Address: 1372 UXBRIDGE ROAD HILLINGDON

Development: Variation of Condition 2 (approved plans) of planning permission ref. 5625/APP/2019/917 dated 10-05-2019 'Three storey building for use as 3 x studio flats and 2 x 1-bed self contained flats, installation of 2 x vehicular crossovers and demolition of existing two storey building' to enlarge two studio flats.

LBH Ref Nos: 5625/APP/2023/937

SCALE 1:50 @A1	DRAWING No.	REV.
DATE MAR '19		
DRAWN LK	4971-9	C

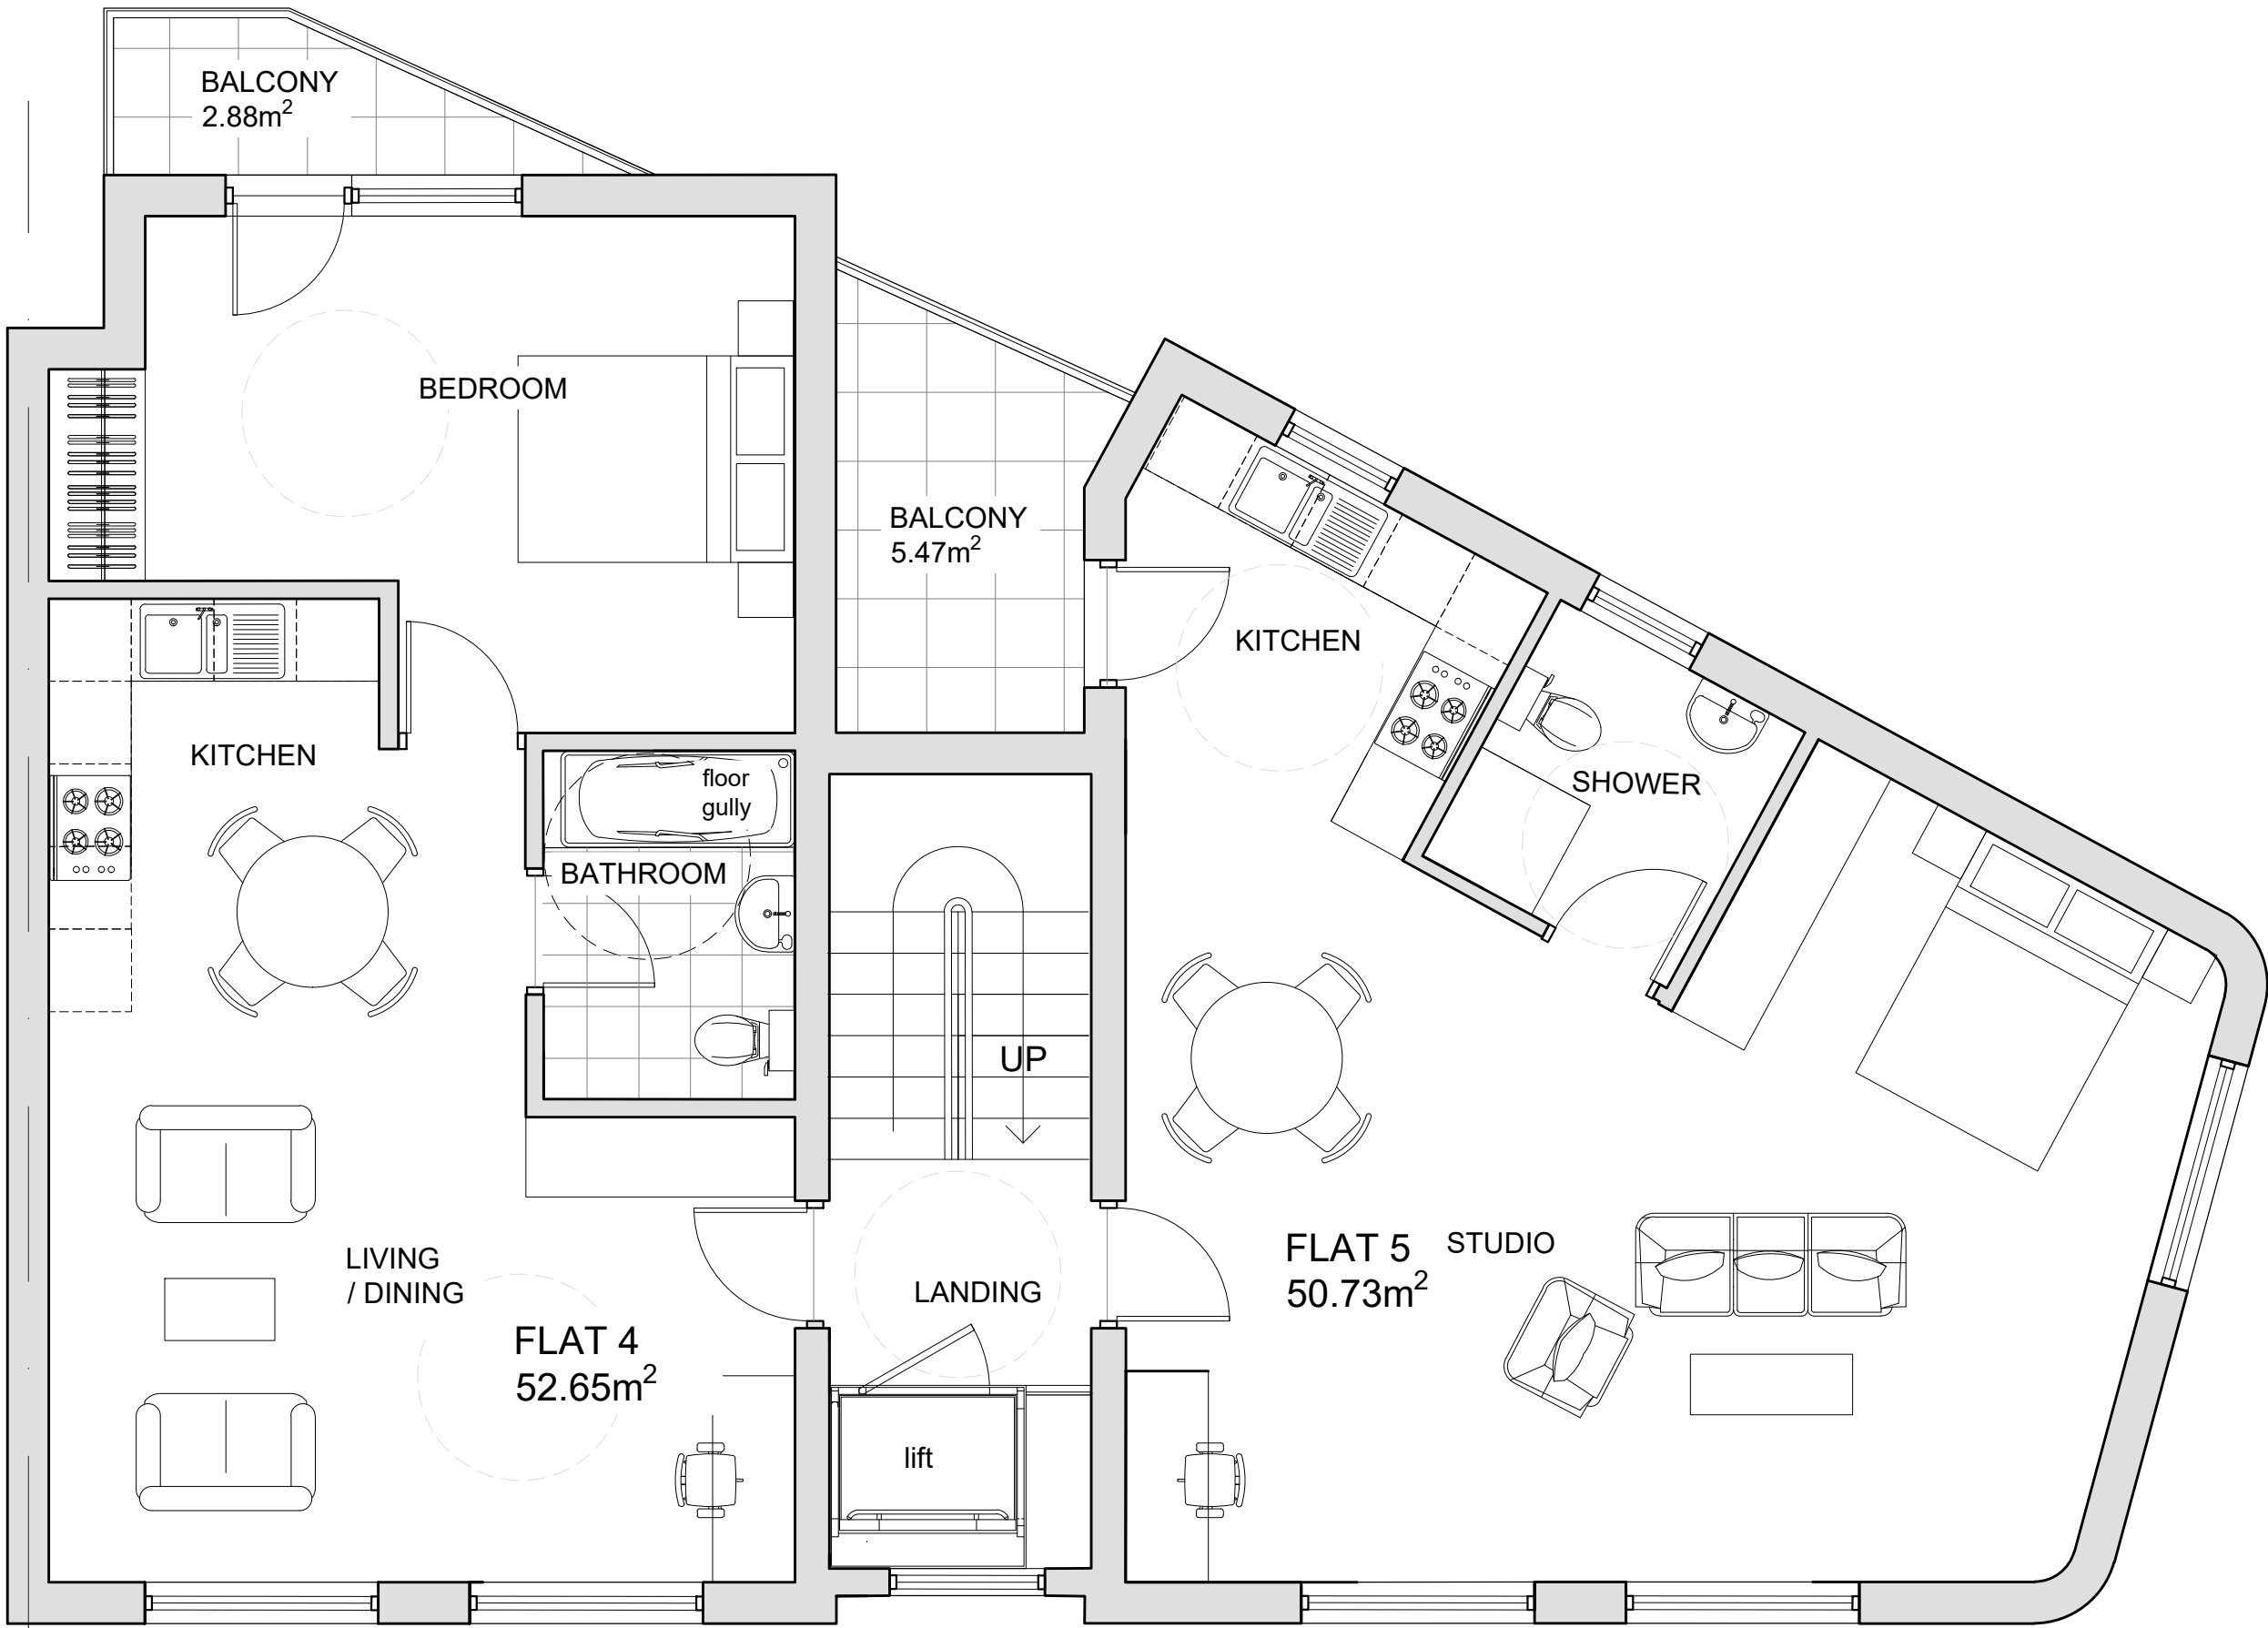
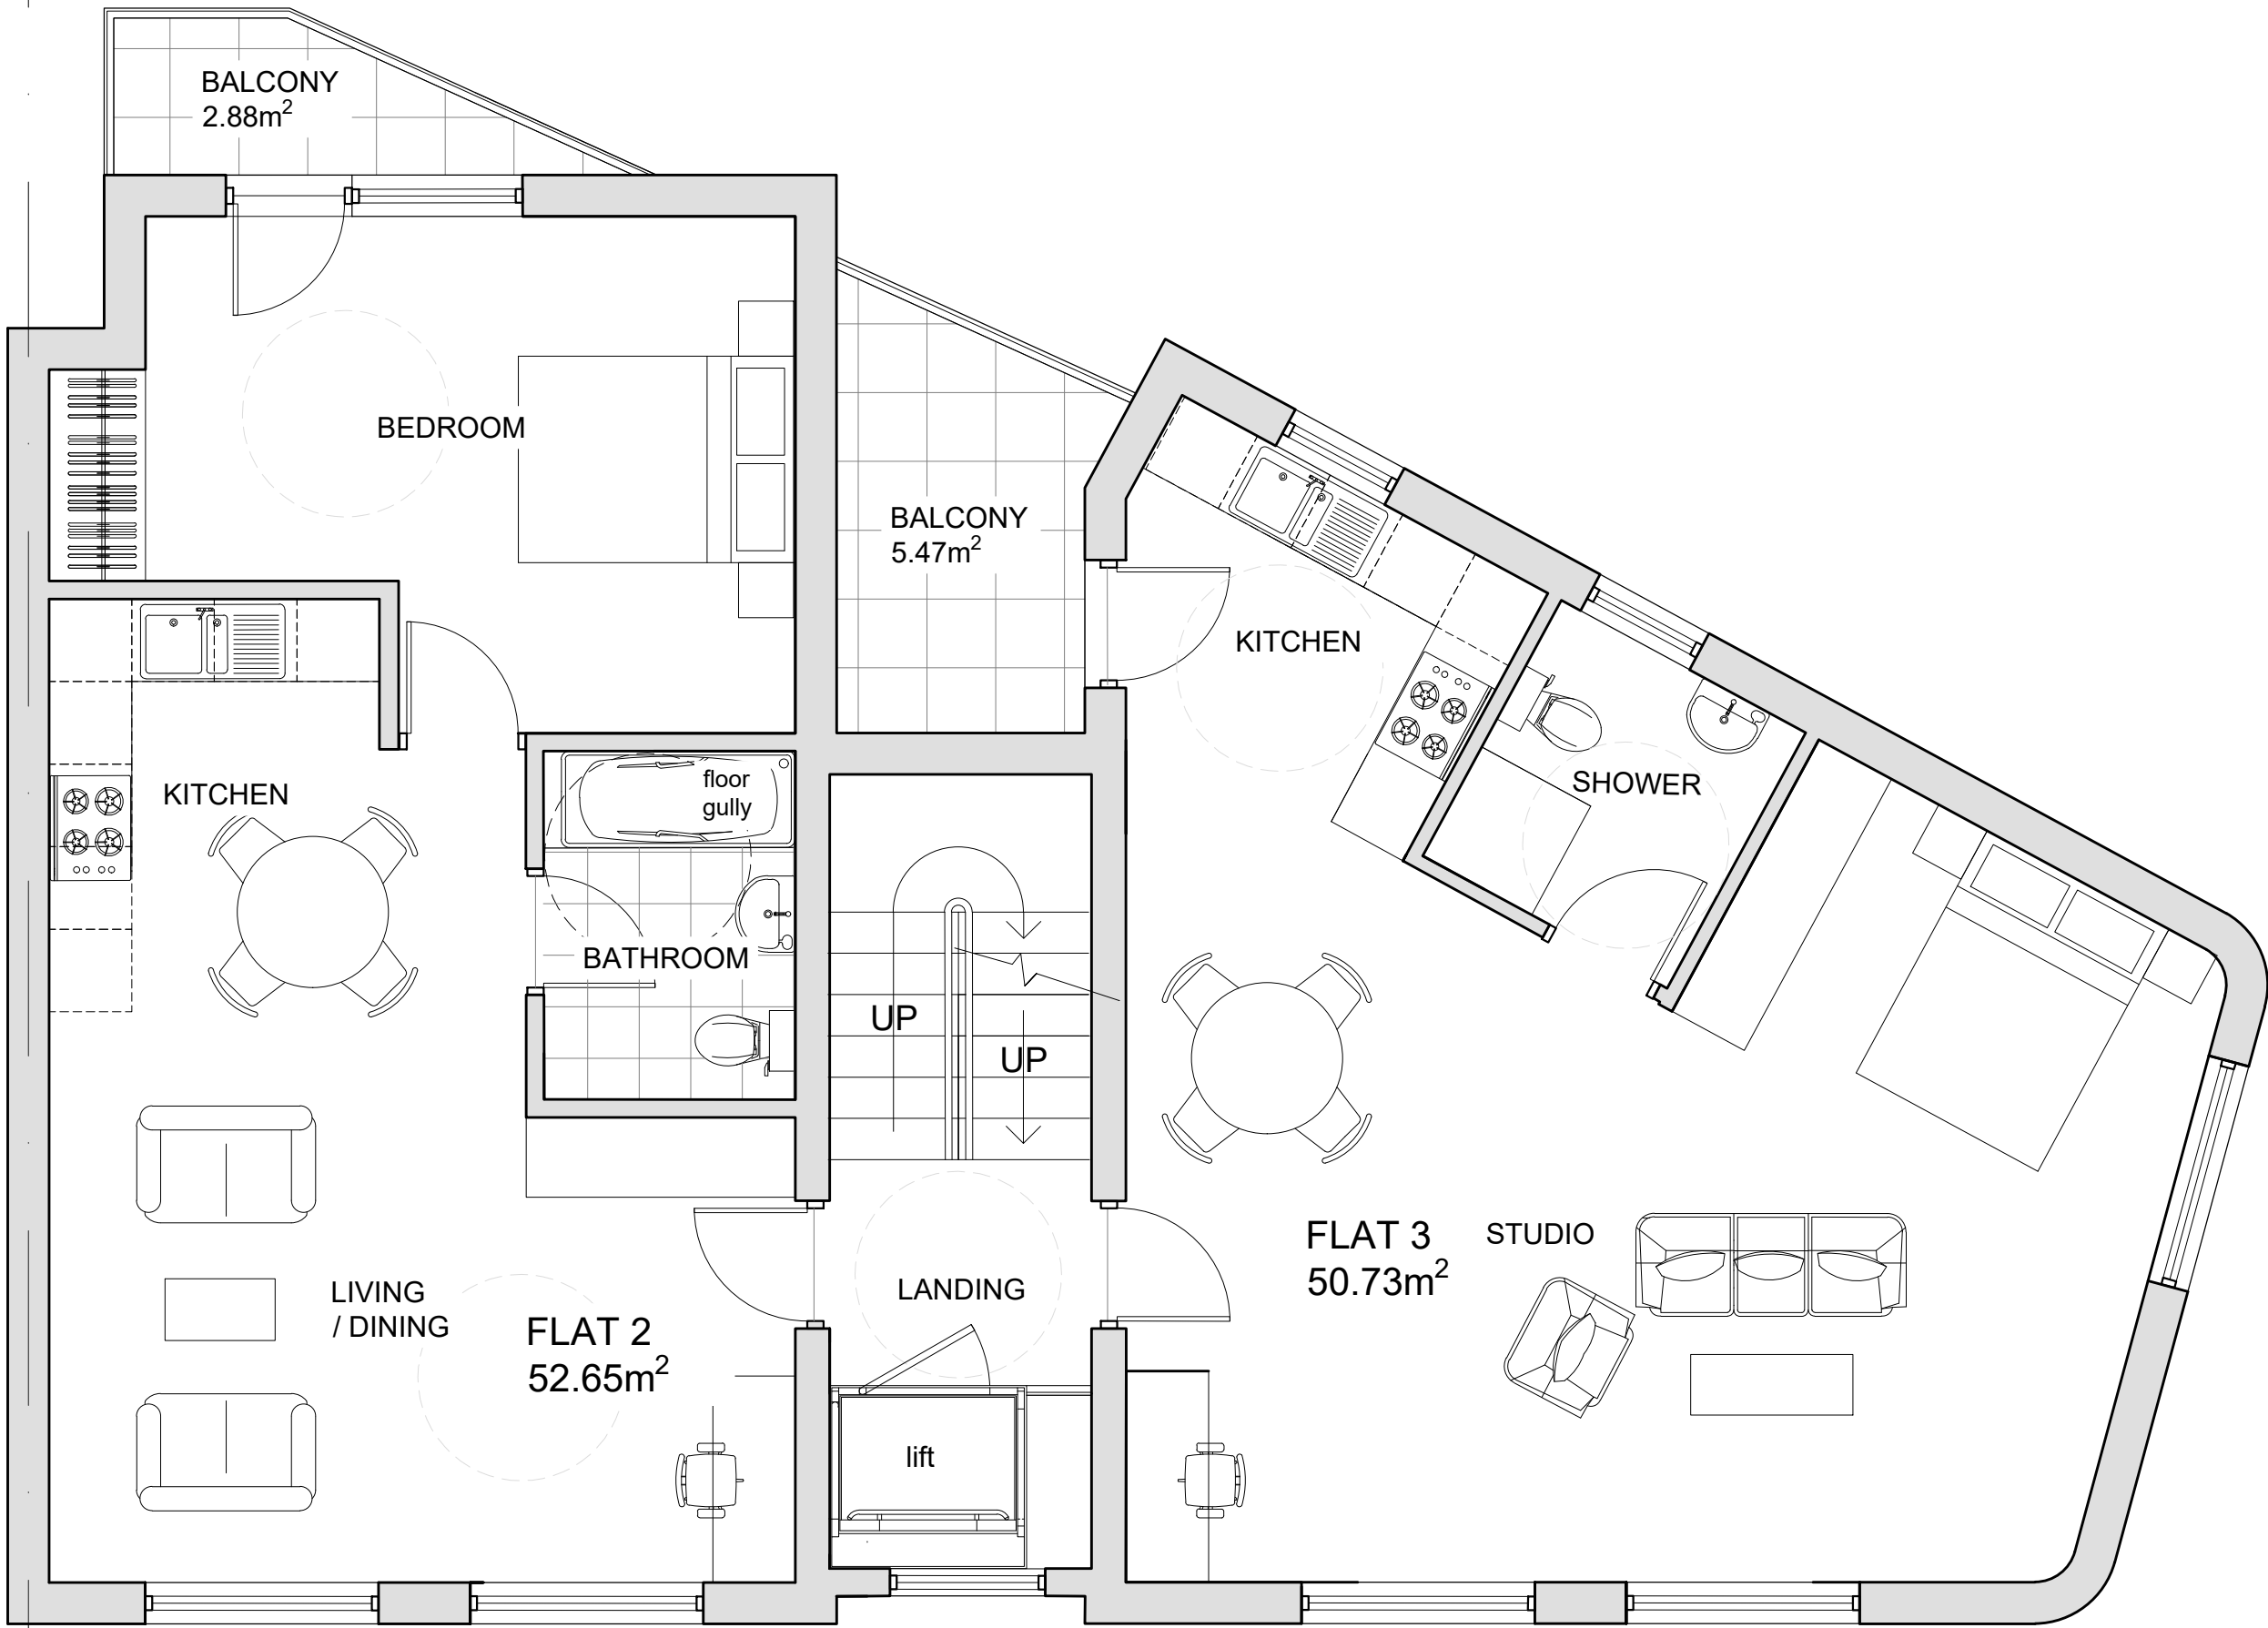
There are a diverse range of styles, designs and materials in the make up of the existing properties within the street scene. The application site is in a particularly prominent and visible location at the end of the a row of properties of similar scale and two-storeys on the corner of Uxbridge Road with Hewens Avenue. The submitted streetscene indicates the approved but not implemented three storey building at number 1380 Uxbridge Road under application reference 71035/APP/2016/4048 for the erection of a three storey building to provide 5 x 2-bed self-contained flats with associated parking, cycle and waste storage. The existing building is not considered to be of any architectural merit and its loss and replacement with a 3 storey building of similar scale to that approved at the nearby site at 1380 is considered acceptable. The proposed amended building would increase the overall bulk of the building towards Hewens Road. The visual impact would appear acceptable from Uxbridge Road, but the additional massing towards Hewens Road, with the additional massing making the upper floors appear top heavy and would be an incongruous alteration to the approved building, of particular concern in this prominent corner location. The undercroft as extended would be a dark and uninviting space, detrimental to the street scene.

The proposal, by reason of its forward projection towards Hewens Road and the increase in the undercroft, in close proximity to the site boundaries, would result in a cramped and incongruous form of development which would detract from the character and appearance of the surrounding area and the visual amenities of the street scene. The proposal is therefore contrary to Policy BE1 of the Hillingdon Local Plan: Part One - Strategic Policies (November 2012), Policies DMHB 11, DMHD 12 and DMHD 1 of the Hillingdon Local Plan Part Two - Development Management Policies (2020).
